FINAL DRAINAGE PLAN AND REPORT

POENITSCH SUBDIVISION

EL PASO COUNTY

Revised
June 18, 2019

# DRAINAGE PLAN

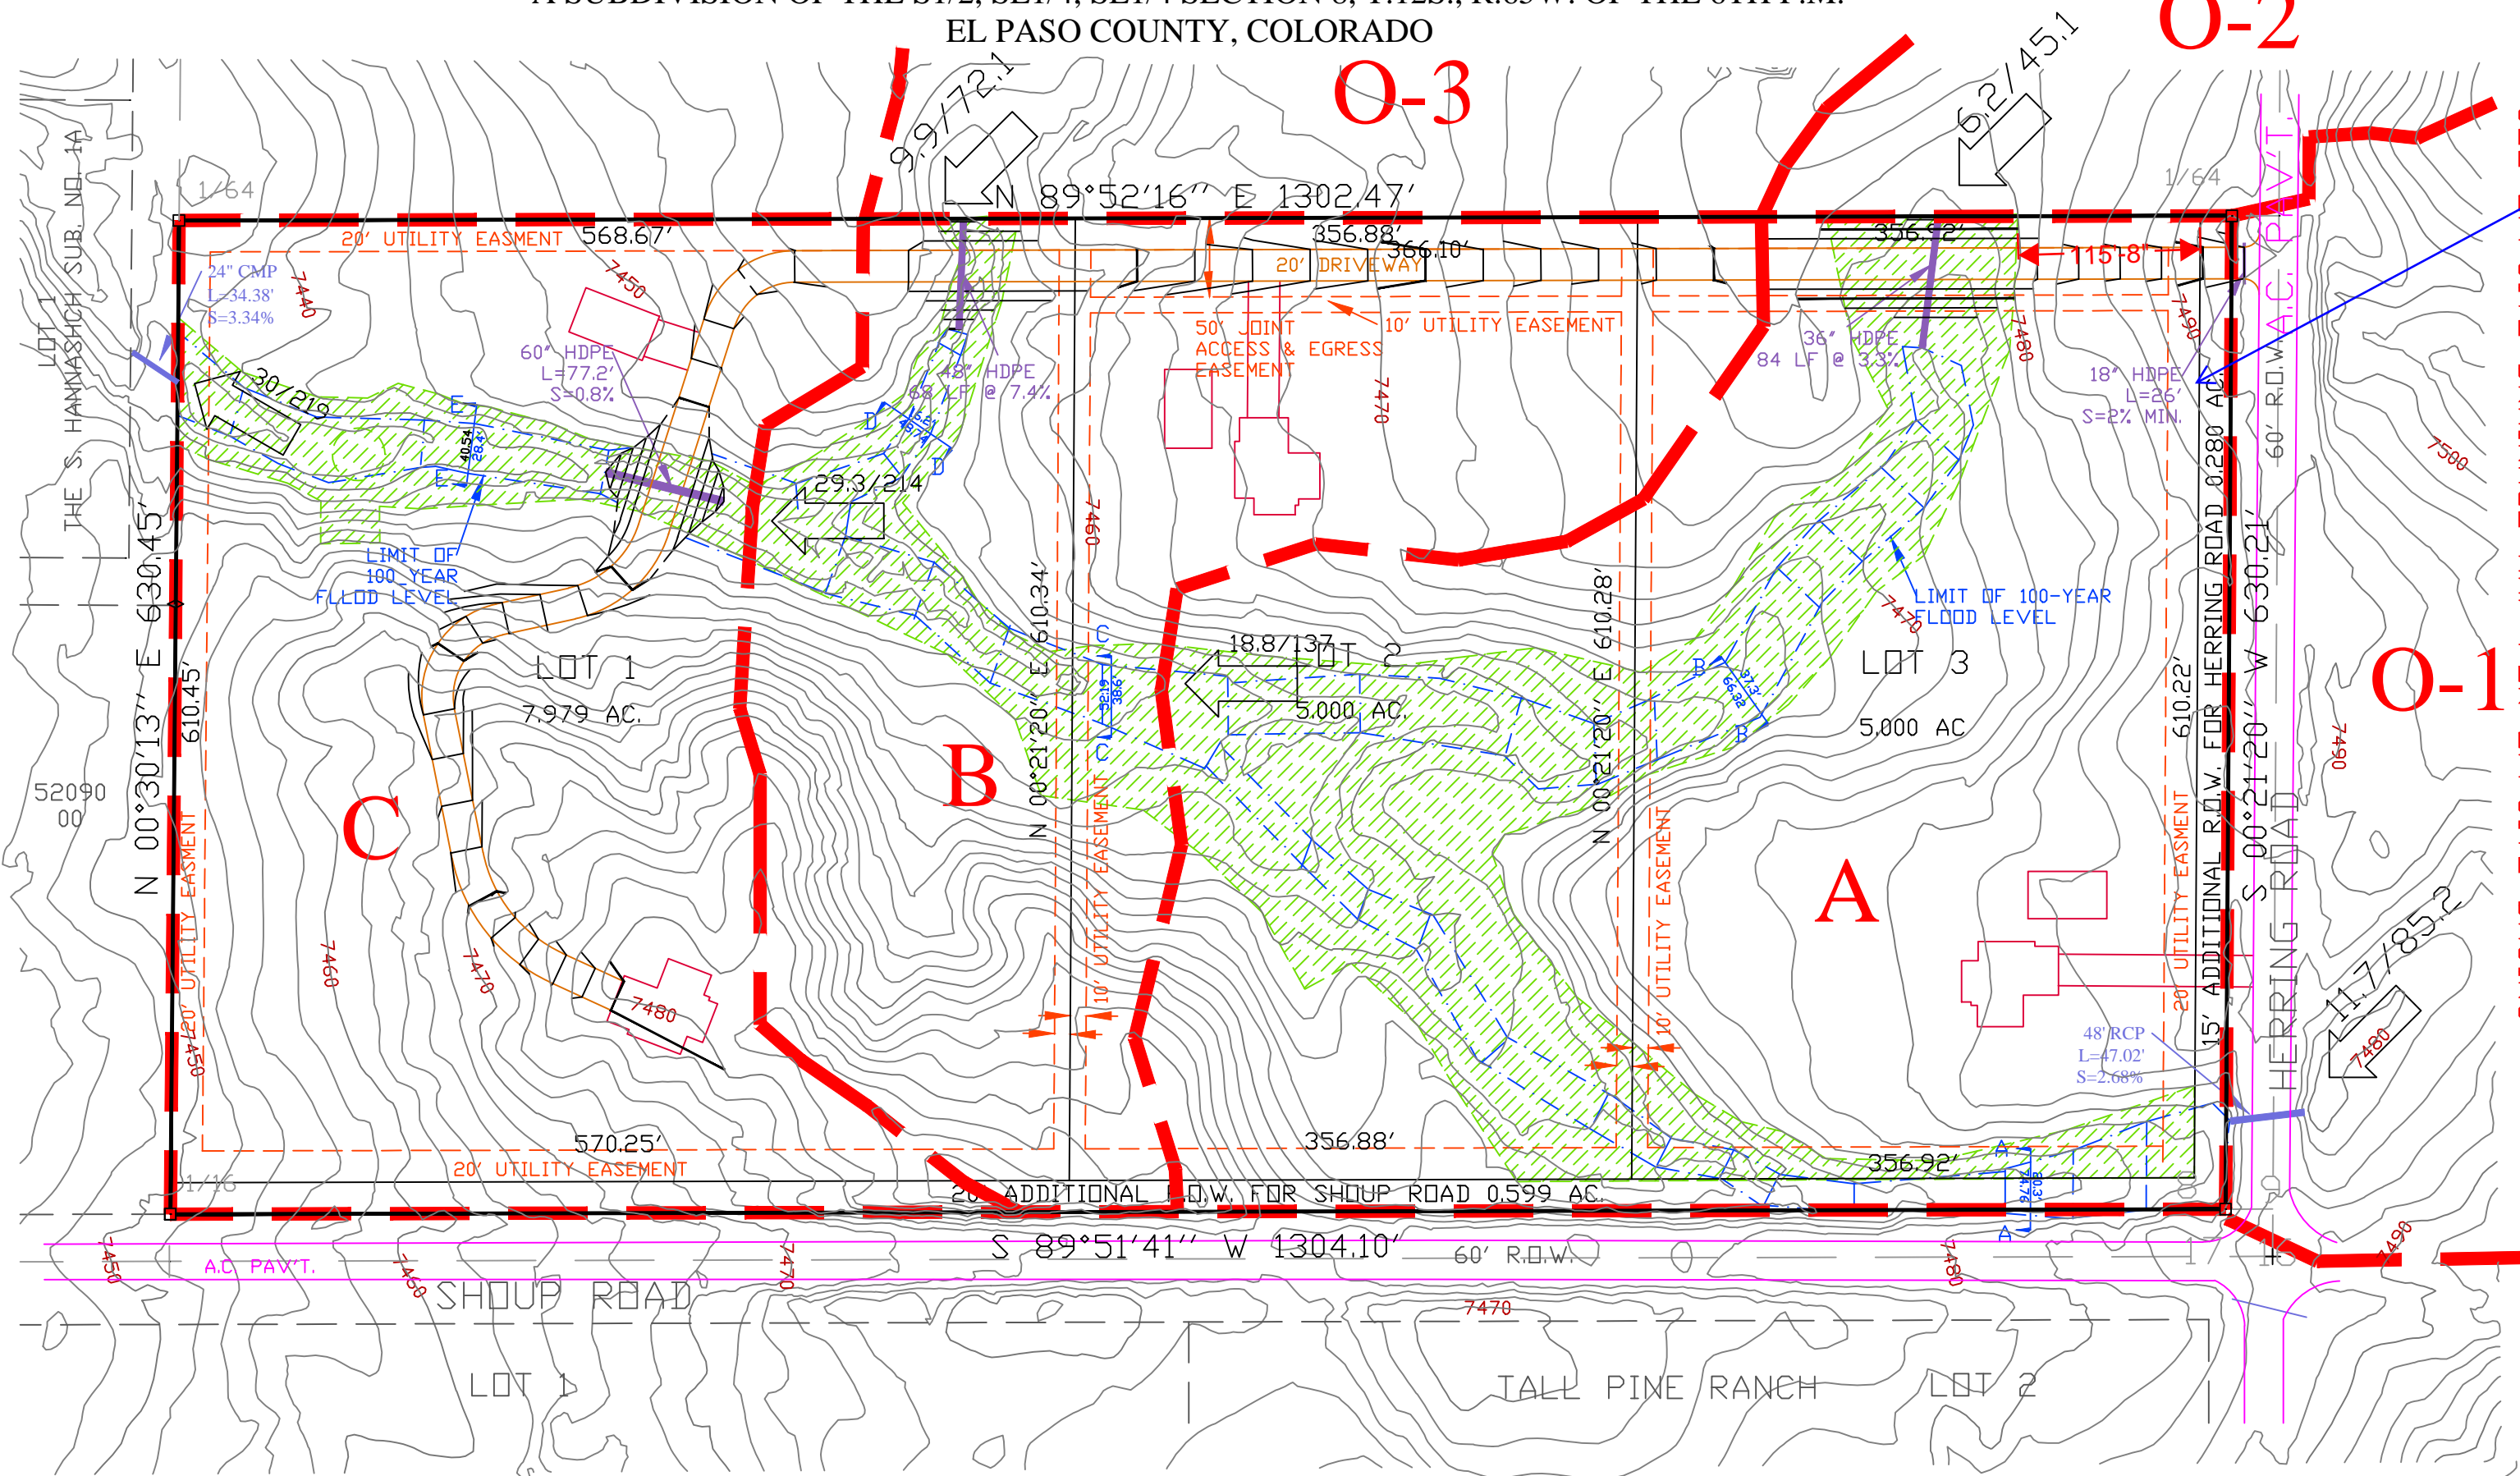
Unresolved. Update the table to be consistent with the revised driveway layout shown on the drainage map.

These values don't match what is shown in the narrative and in the drainage map. Please clarify and revise.
